Borough Council of King's Lynn and West Norfolk Relevant Representation Summary

At the Council meeting on 25 February 2021, a motion was passed to object to the principle of the proposal for an energy from waste facility in Wisbech. It is important to note that this remains in place and is unaffected by this specific technical consultation response.

Figure 8.1
Air quality survey monitoring locations

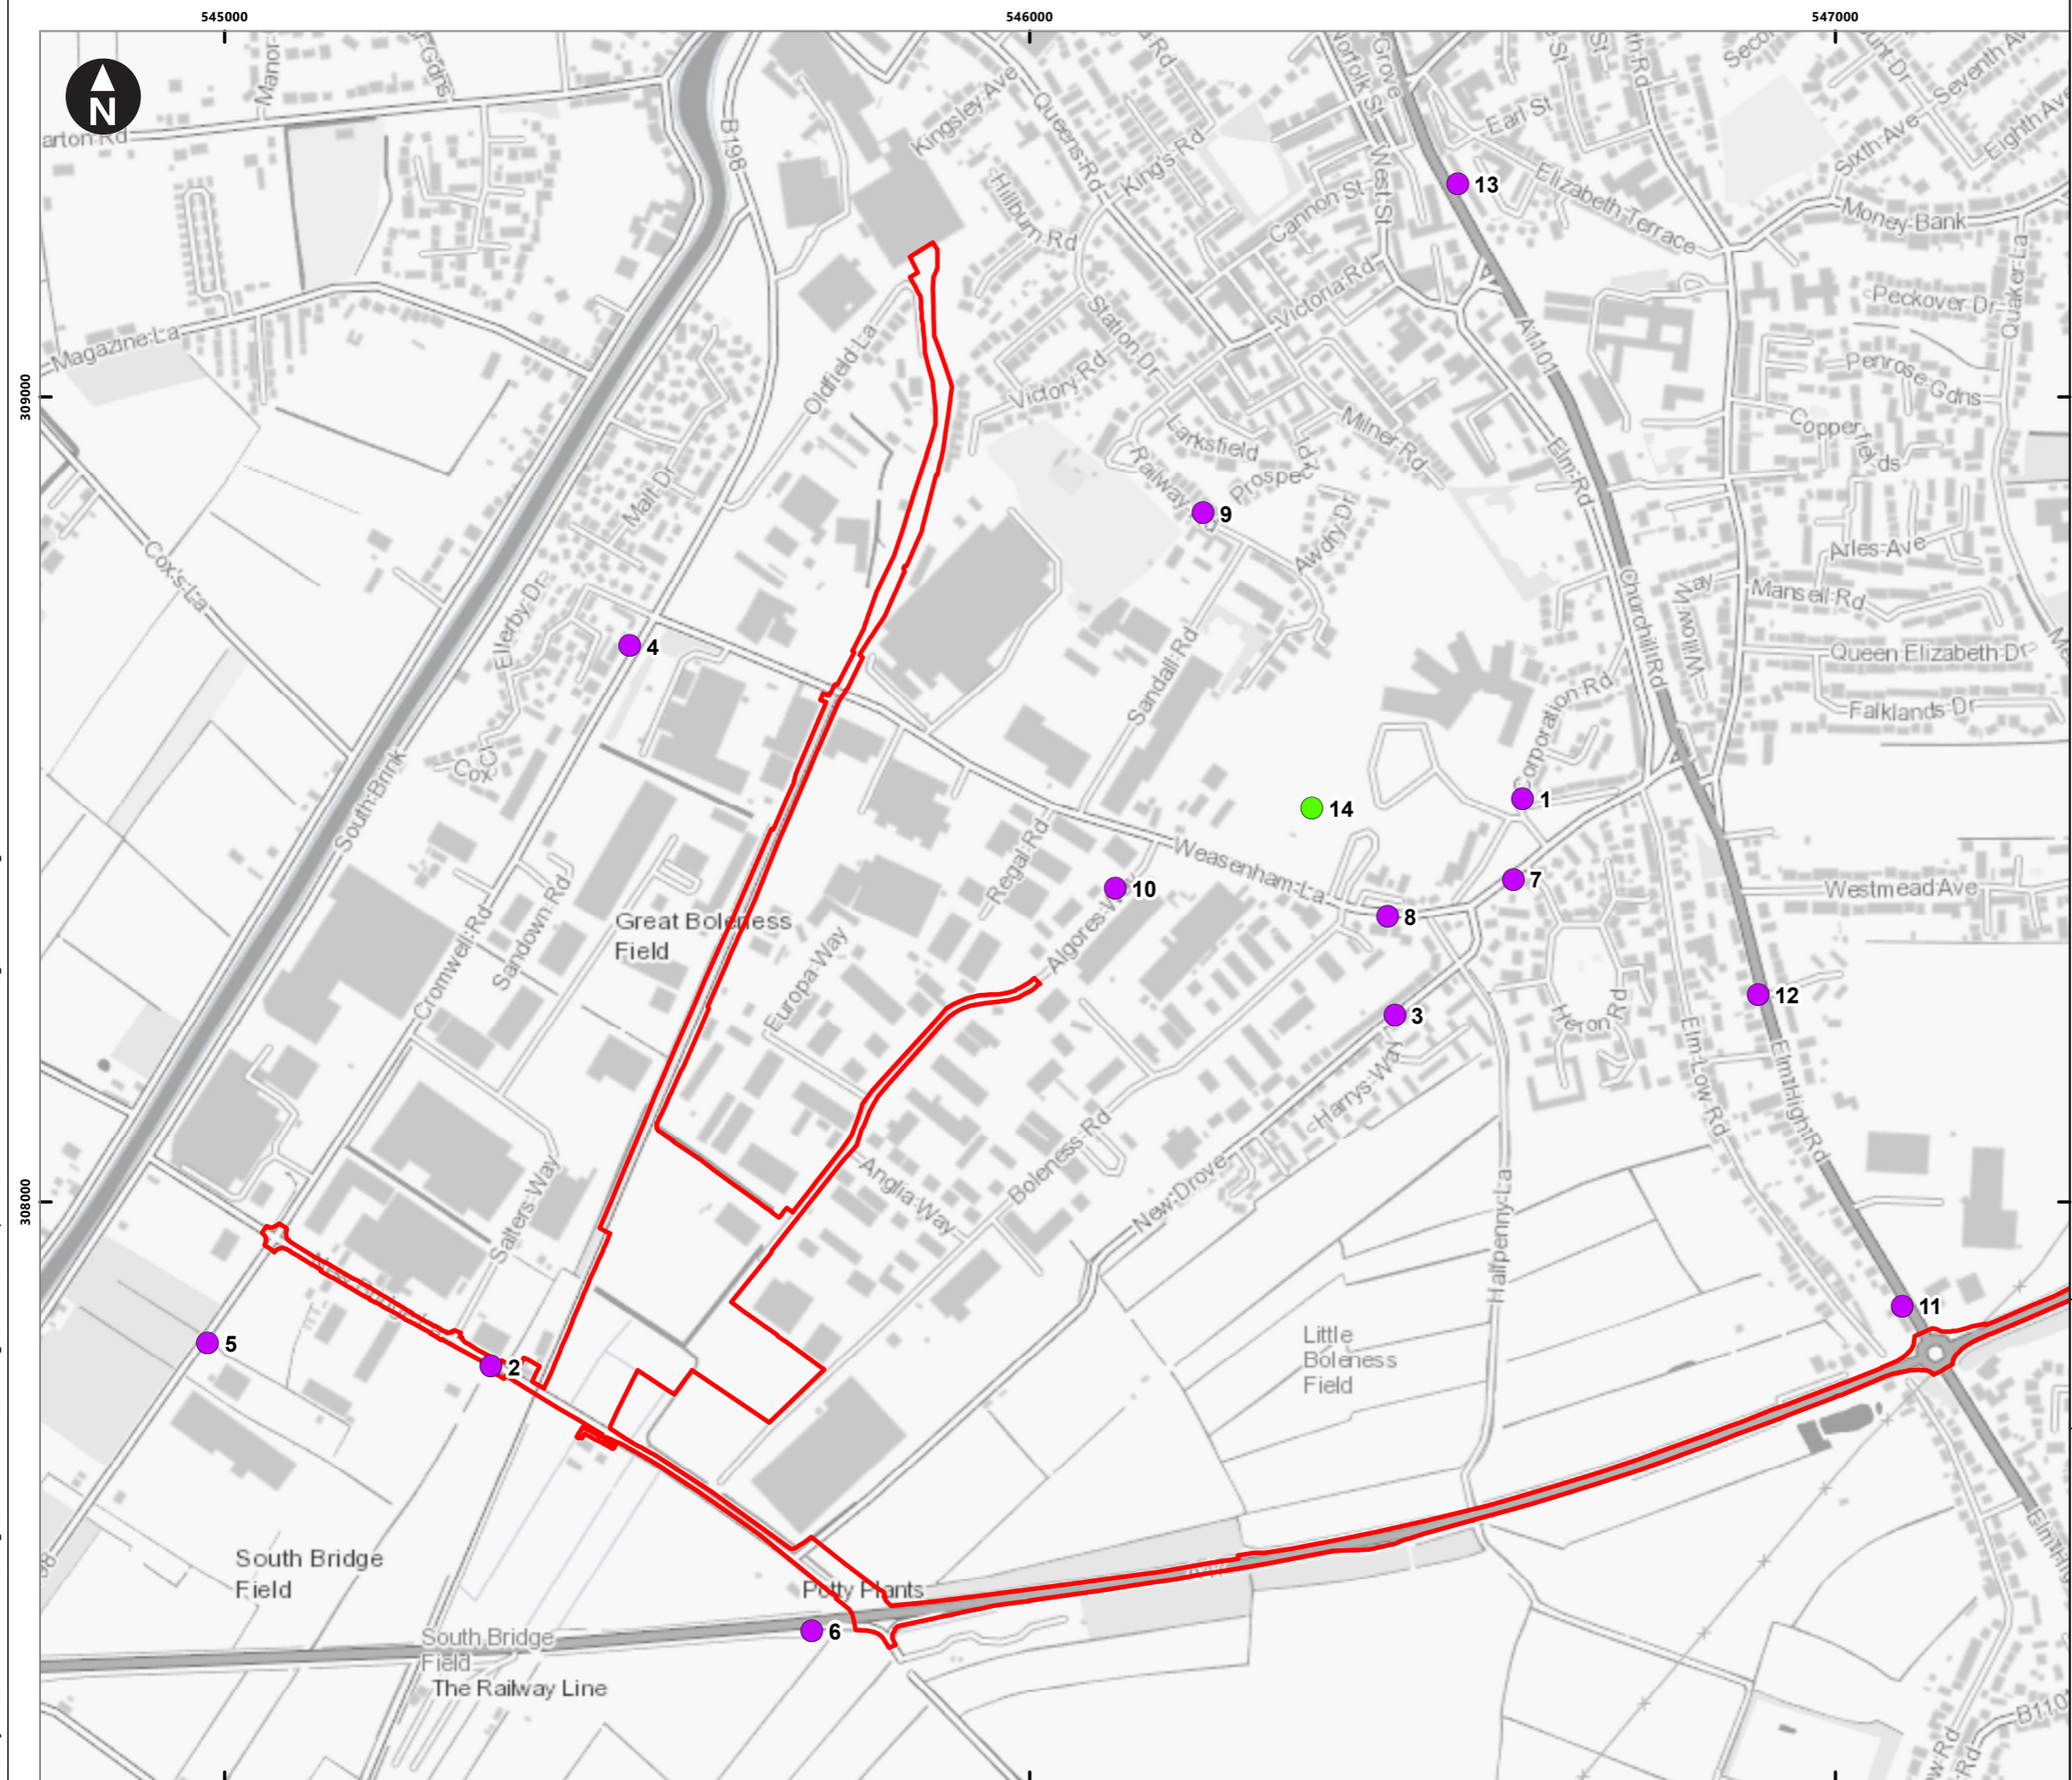
To help understand background air quality and monitor changes in traffic we have already established diffusion tube (NO₂) monitoring points in the area. As confirmed at the earlier scoping opinion PINS had recommended that all air quality monitoring locations should be identified on a plan. There is also Dept. of Transport traffic survey points along parts of the network that show actual daily movements.

Figure 8.5
Annual mean NO2 concentration contours

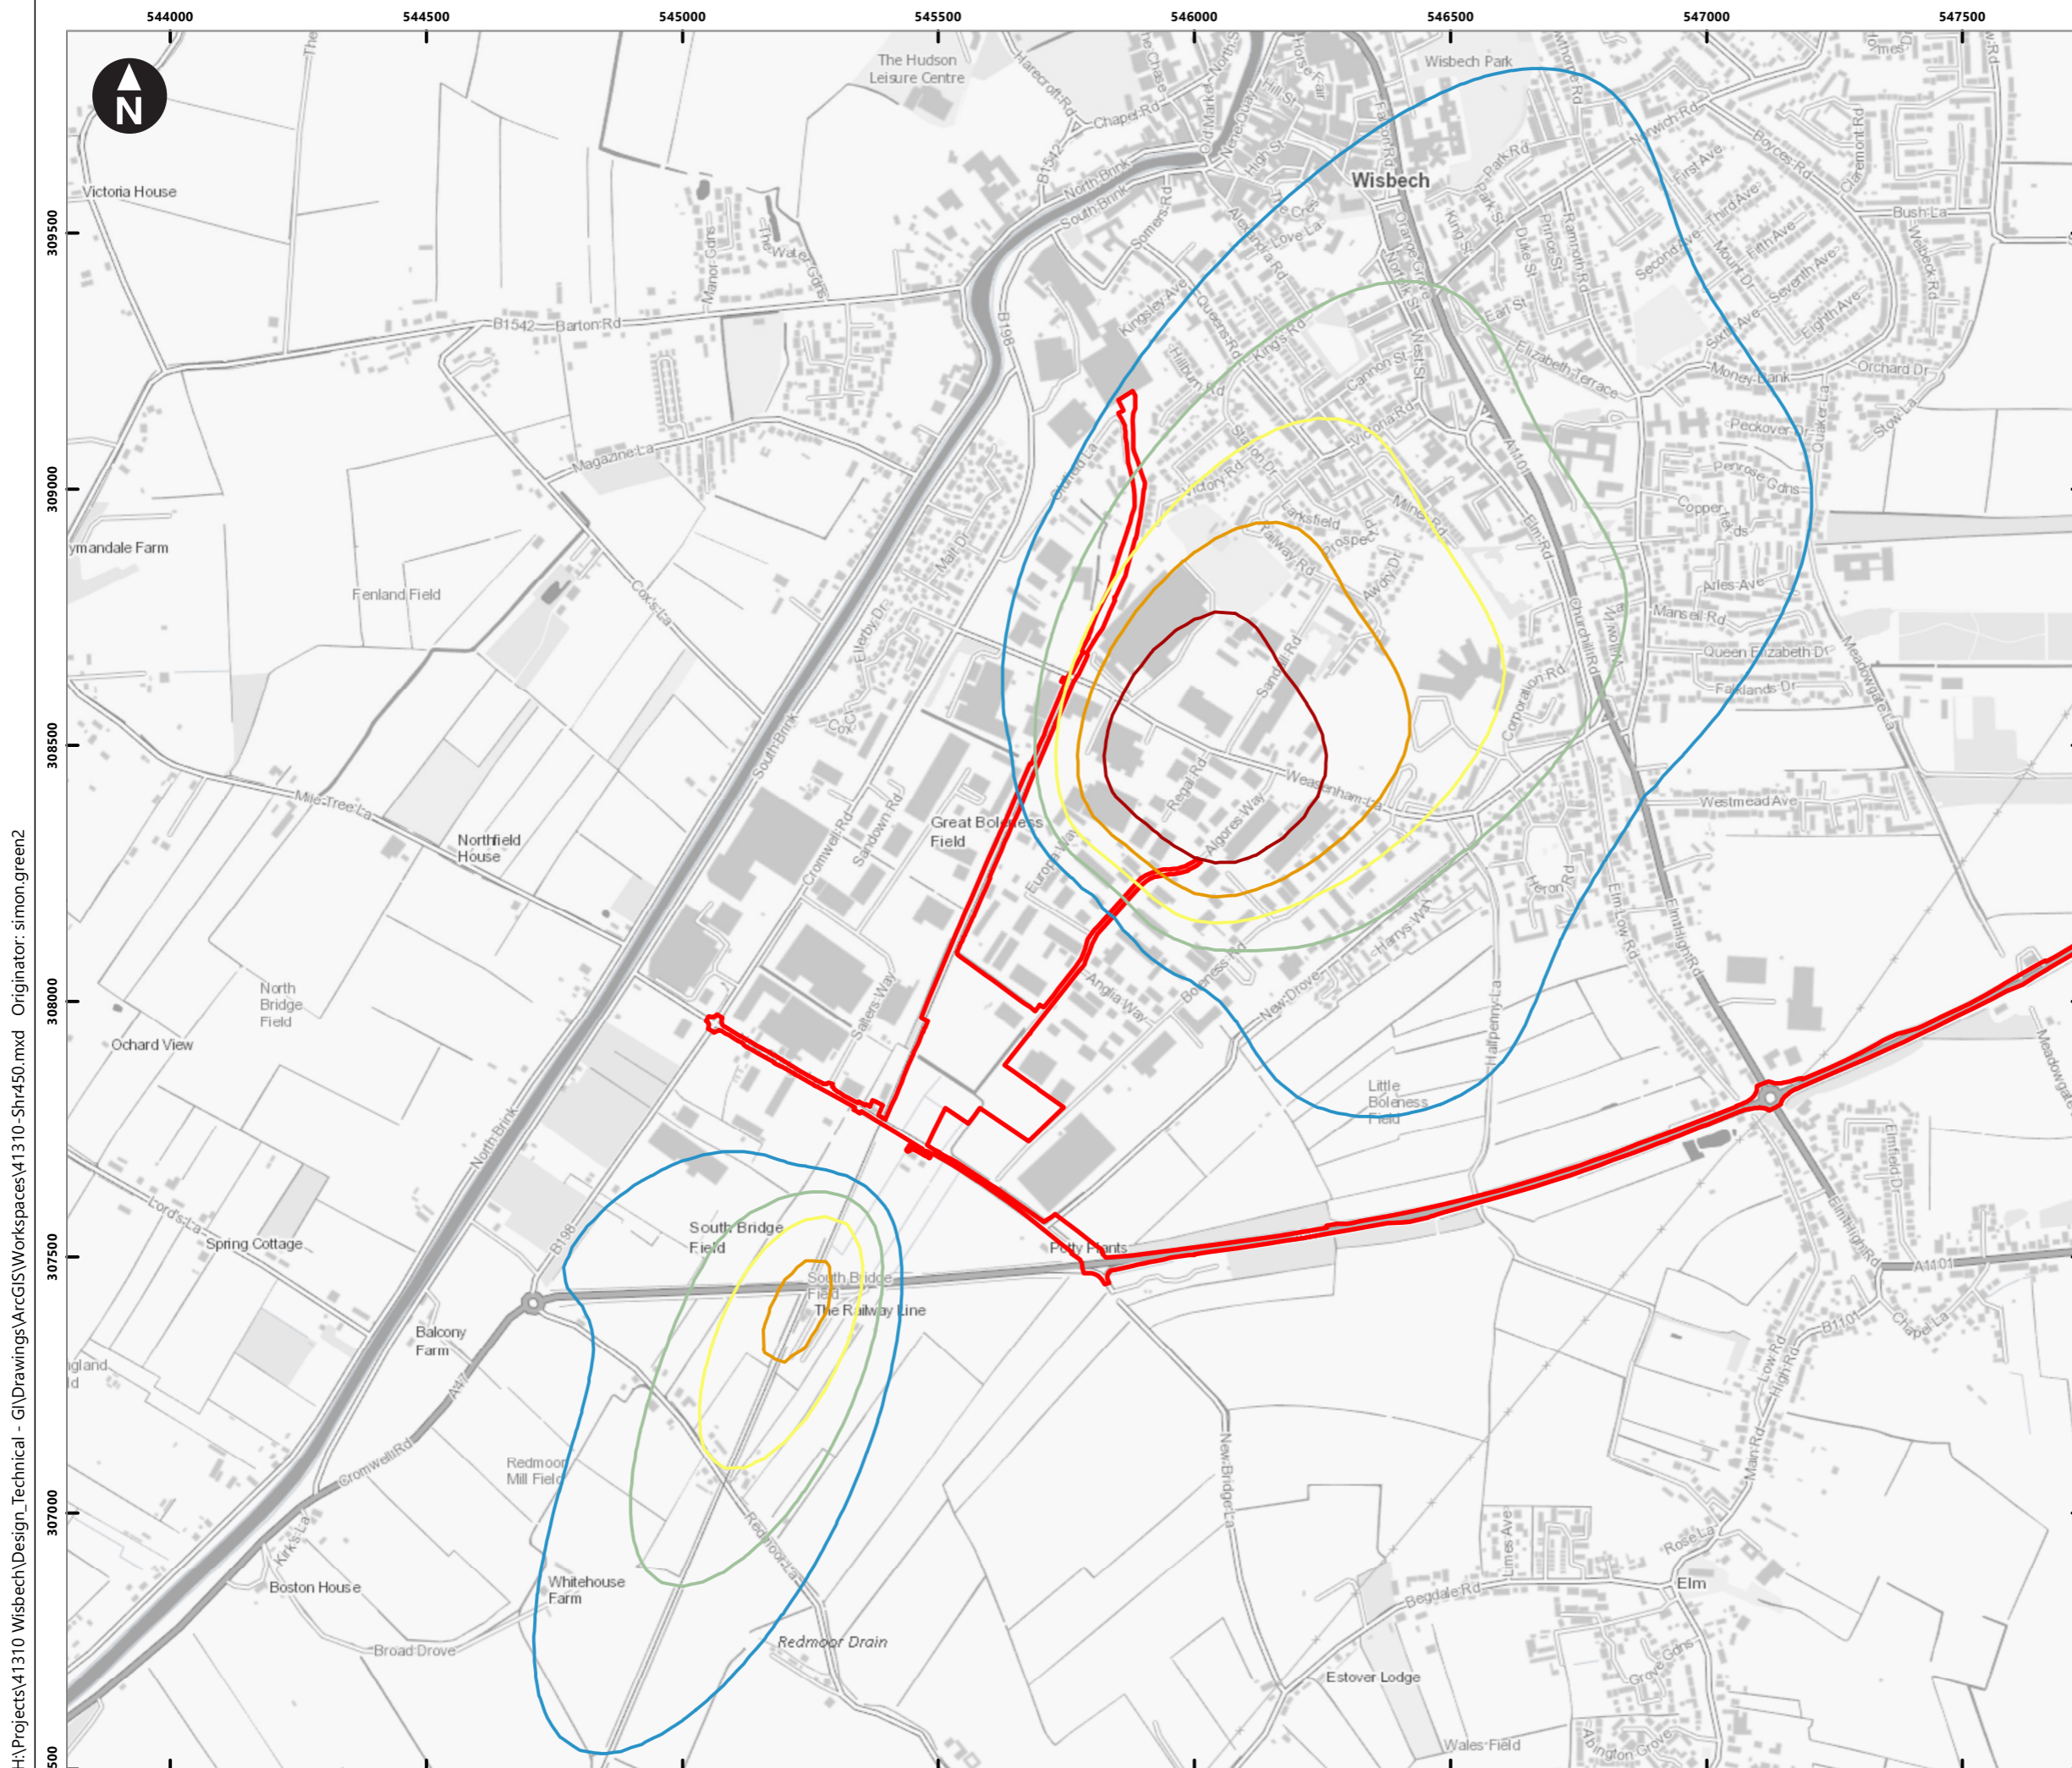
The plume is presented spatially by NO₂ concentration contours for emissions from the chimney only (section 6.2.2) with both annual and short-term means within Figures 8.5 and 8.6 presented. As can be seen there are two areas affected from the plume as it disperses back towards ground level. The plume extends for the most part in a NE direction from the site but with a slight deflection towards the A47.
